Date: 03-Feb-2026  
Our Ref: 2025/93465

**Application for a non-material amendment following a grant of planning permission,  
Town and Country Planning Act 1990**

**Non material amendment to previous permission 2021/93567 for demolition of  
existing commercial buildings and erection of 180 dwellings with associated works  
Land Off, Westgate, Cleckheaton, BD19 5DR  
Application Number: 2025/93465**

Project: M3-301 BRICK AS END

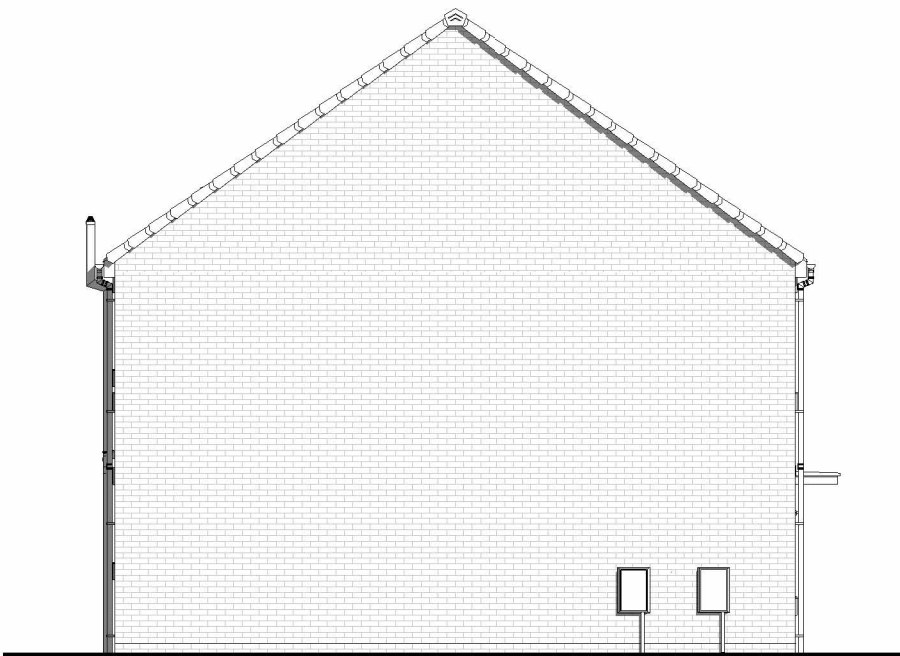
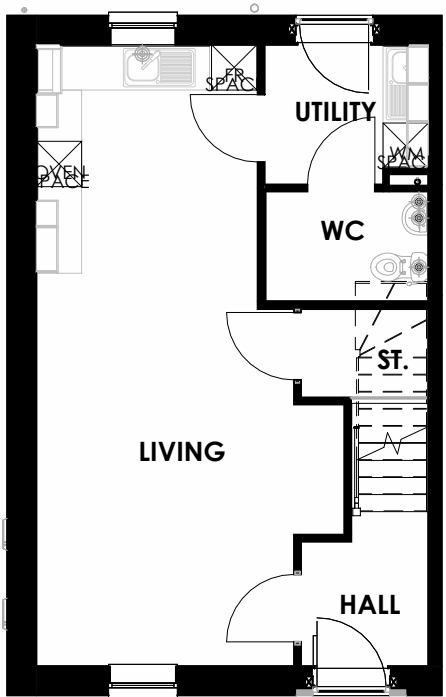
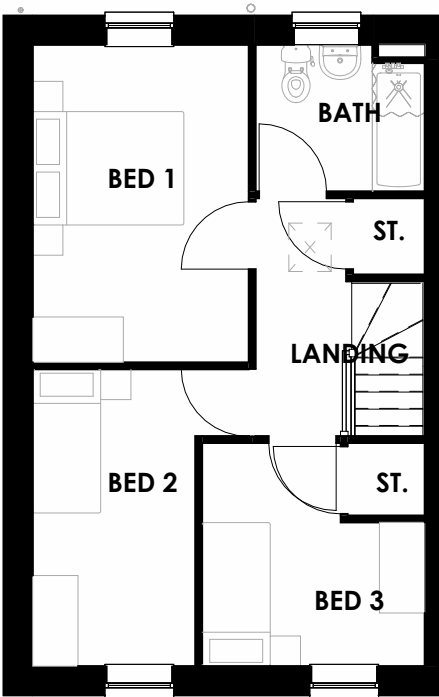
- Canopy: Additional brick detailing has been incorporated around the front door, with the addition of a Glass Reinforced Plastic canopy.
- Windows: A header brick detail has been introduced between the ground floor and first floor windows, enhancing the architectural character of the dwellings.
- Brick Detailing: A distinctive brick course detailing has been incorporated along the façades of the dwellings to provide visual interest on all elevations and improve the overall streetscape of the development.

- MY AL – 451 Planning Stone (Dwg: 101) replacing MY A-451 (Stone),
- MY AL – 451 Planning Brick (Dwg: 100) replacing MY A-451 (Brick),
- M3-301 Stone As End Planning Drawing (Dwg: 01) replacing MY A-352 (Stone),
- M3-301 Brick As End Planning Drawing (Dwg: 01 Rev B) replacing MY A-352 (Brick – Red and Buff),
- MY AL – 251 Planning Stone (Dwg: 101) replacing MY A-251 (Stone) and MY A-251 (Heads and Sills – Plots 1–4 and 179–180),

I can confirm that the proposed non-material amendments identified above are acceptable and are hereby approved.

HOUSE TYPE CODE:	MY AL - 251
SCALE @A2 -	1 : 100
Drawn:	LS
Checked:	MB
Dwg No:	100

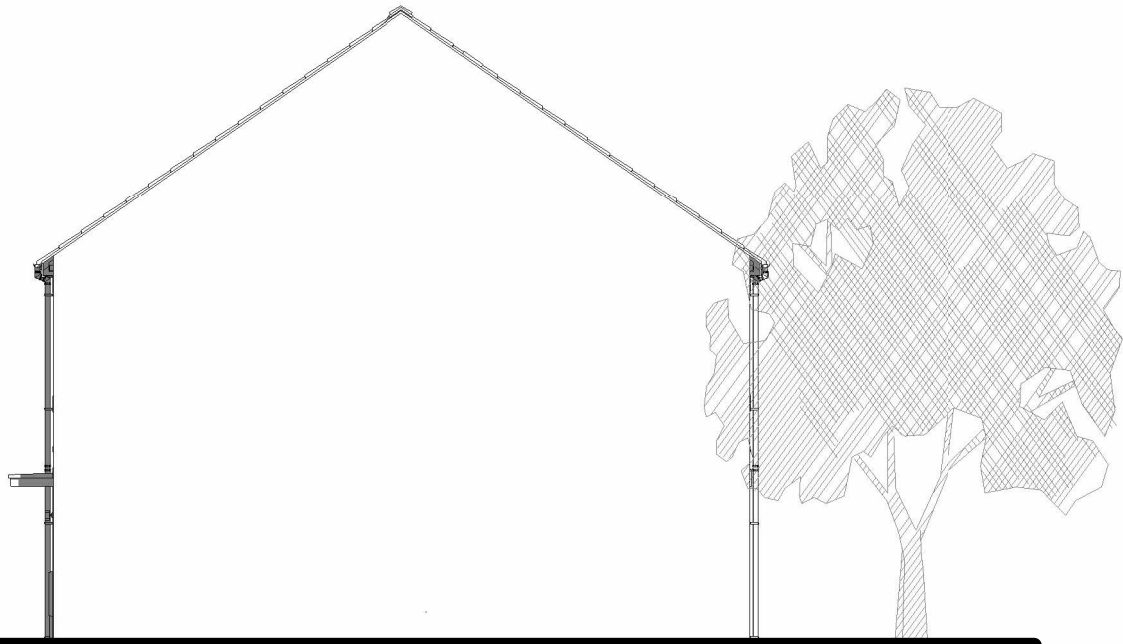
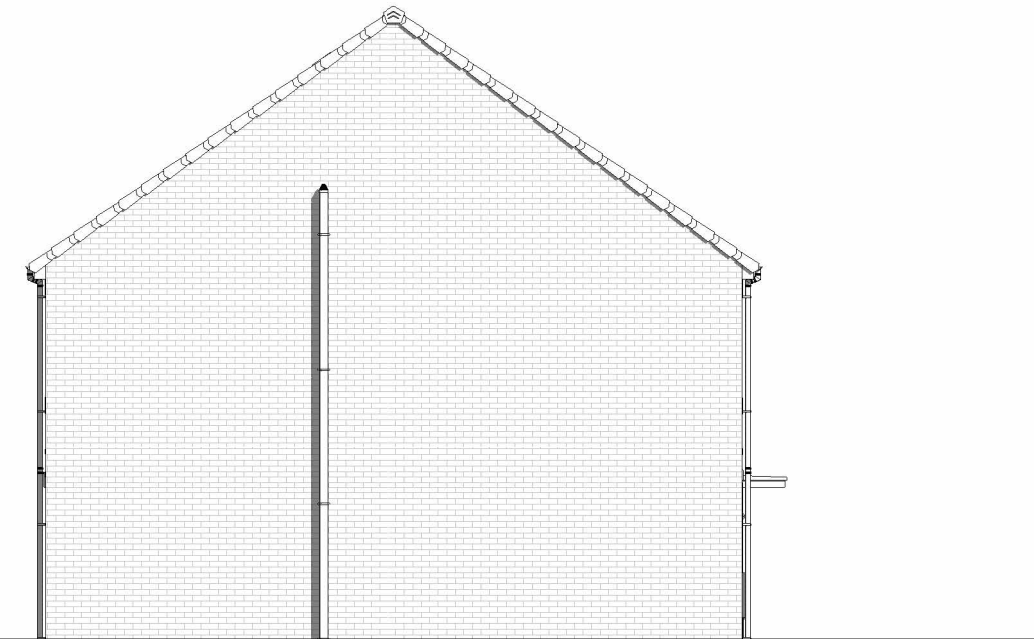
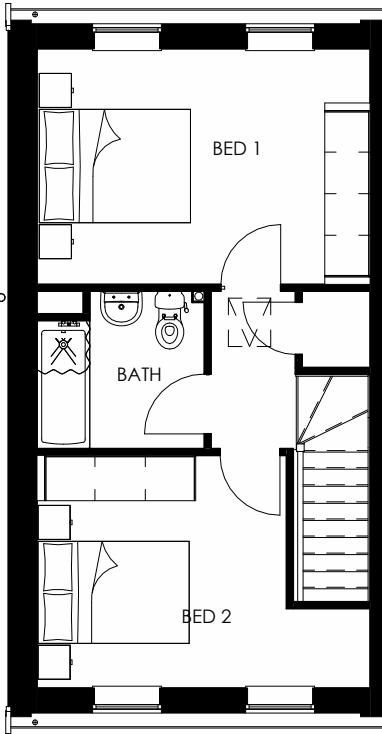
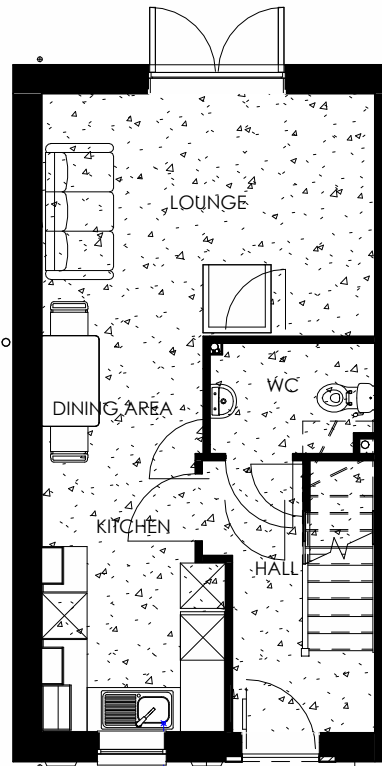
- MY AL – 251 Planning Brickwork (Dwg: 100) replacing MY A-251 (Brick – Red and Buff),
- M3-604 Stone Westgate, Cleckheaton Planning Drawing (Dwg: 01) replacing M3-601,
- HT2A – Planning Drawing (Dwg: BY00099-P1-01-A3) replacing HT2A – Planning Drawing approved under Non Material Amendment reference 2025/92574.
